Application No: FG/32/25/HH

Site Address: 1 Greenways Crescent Ferring BN12 5EF

Description of works: Erection of 1.8m high close boarded timber fencing along the eastern boundary.

Thank you for your internet representation made on 20th April 2025 which has been recorded as an objection with the comments as follows:

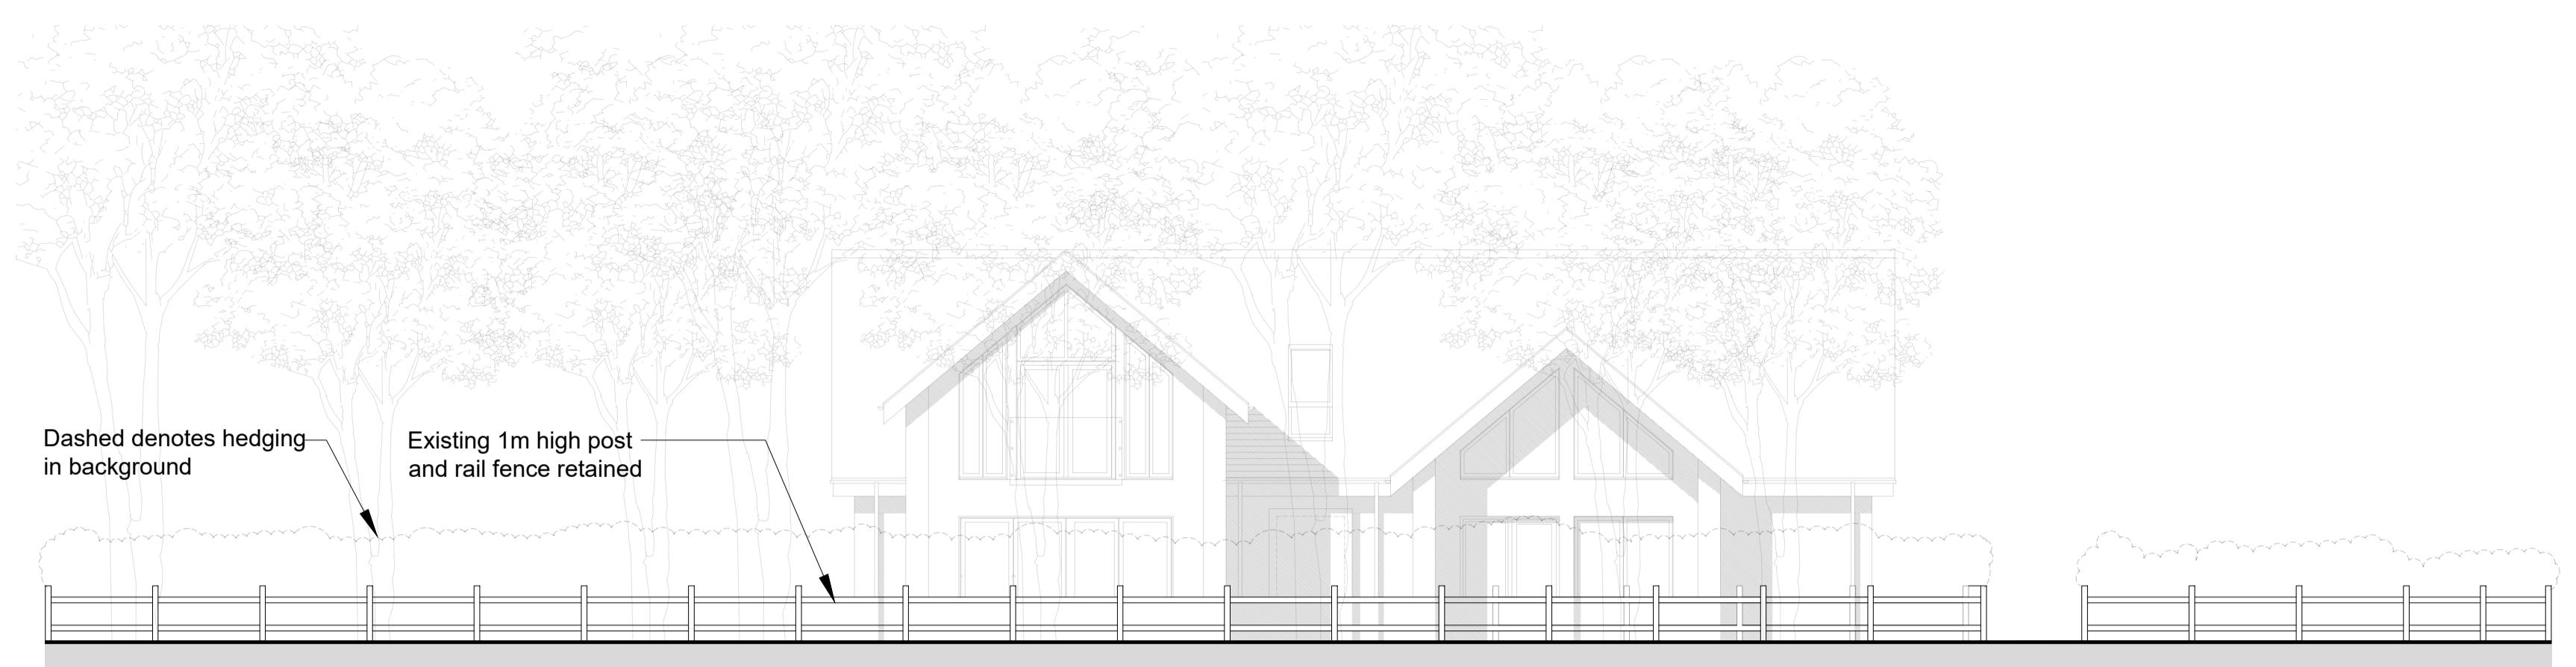
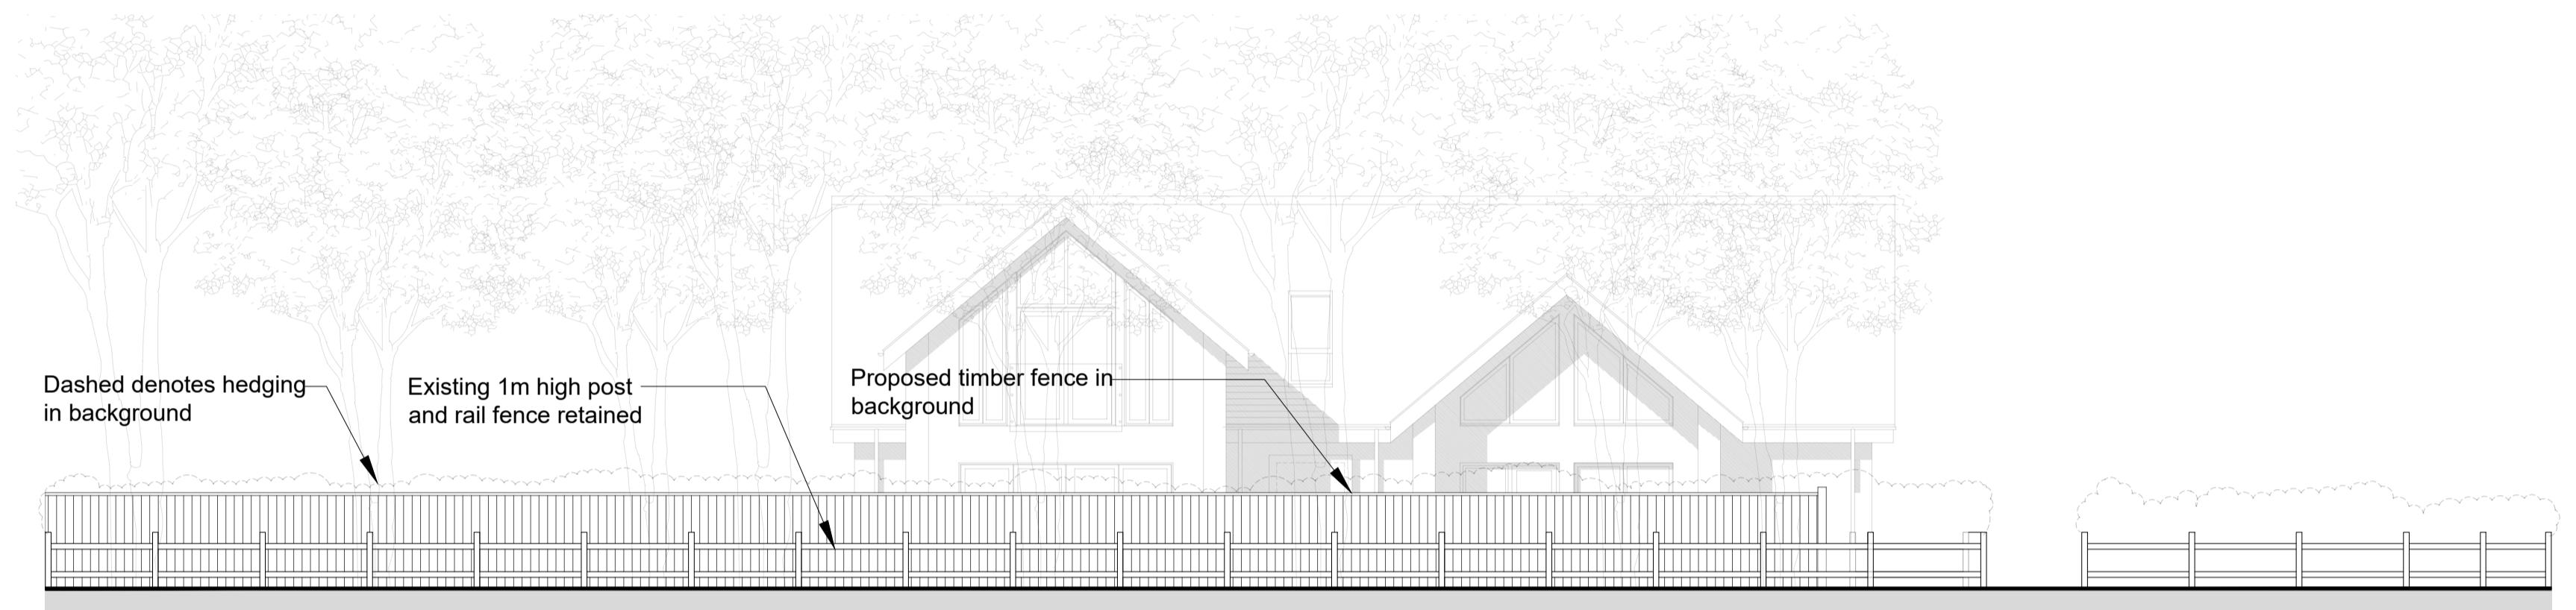
(2) It is my understanding that my own property Deeds give me a legal right of way over the first two metres of land measuring back from the kerbstone of the tarmac road. I am not a surveyor, but it seems to me that this planning application proposes the erection of a fence nearer to the kerbstone than 2 metres, thus frustrating my right of way. Indeed, the existing "post and rail" fence is nearer to the kerb than 2 metres, which I do not believe to be permissible. Of course, several other houses in Greenways Crescent have already blocked the grass verge by planting hedges and shrubs on that 2 metre strip of land, forcing pedestrians to walk in the road amongst the traffic, instead of being able to walk safely on the verge, so perhaps the Council considers that blocking the verge is now acceptable? If so, I should be obliged if the Council would confirm this for me.

(3) The Council's Planning Portal states that fences next to a road shall be no higher than one metre. The existing "rail and post" fence already breaches that one metre rule, before we even consider a possible new 1.8 metre fence.
